Recommendation Report for Planning Permission for Works or Extension to a Dwelling

REF NO: AW/159/20/HH

LOCATION: 3 Wells Crescent
Aldwick
PO21 3RP

PROPOSAL: Rear extension.

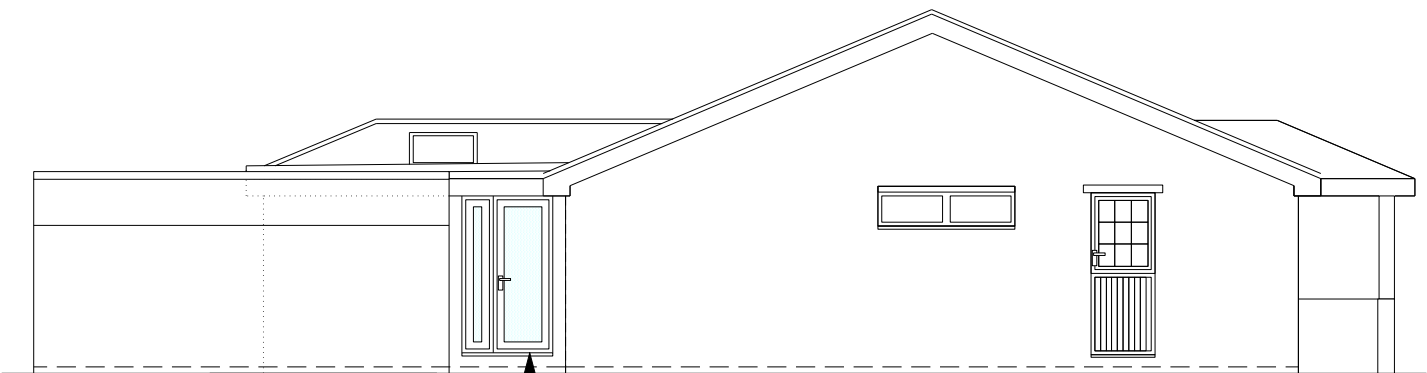
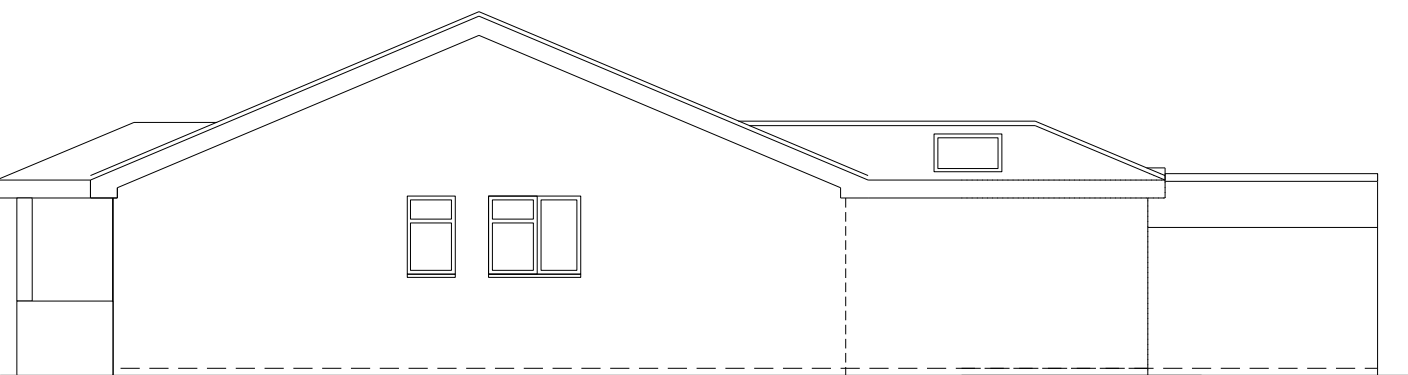
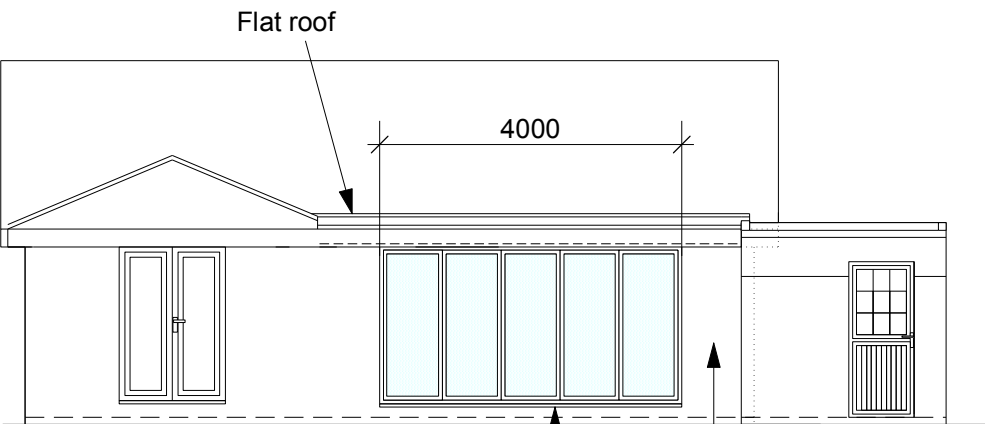
The extension has a maximum length of 3.95m a width of 5.64m and height of 2.68m. Due to the size and position of the extension which will be 2.75 to the South boundary and 4.8m from the North boundary. The development is therefore not considered to appear adversely overbearing.

There will be a new door on the south elevation and well as bi-fold doors on the rear West elevation. These will all be at ground floor level and with fencing along the boundary, and with views over the garden, it is not considered to give rise to adverse overlooking.
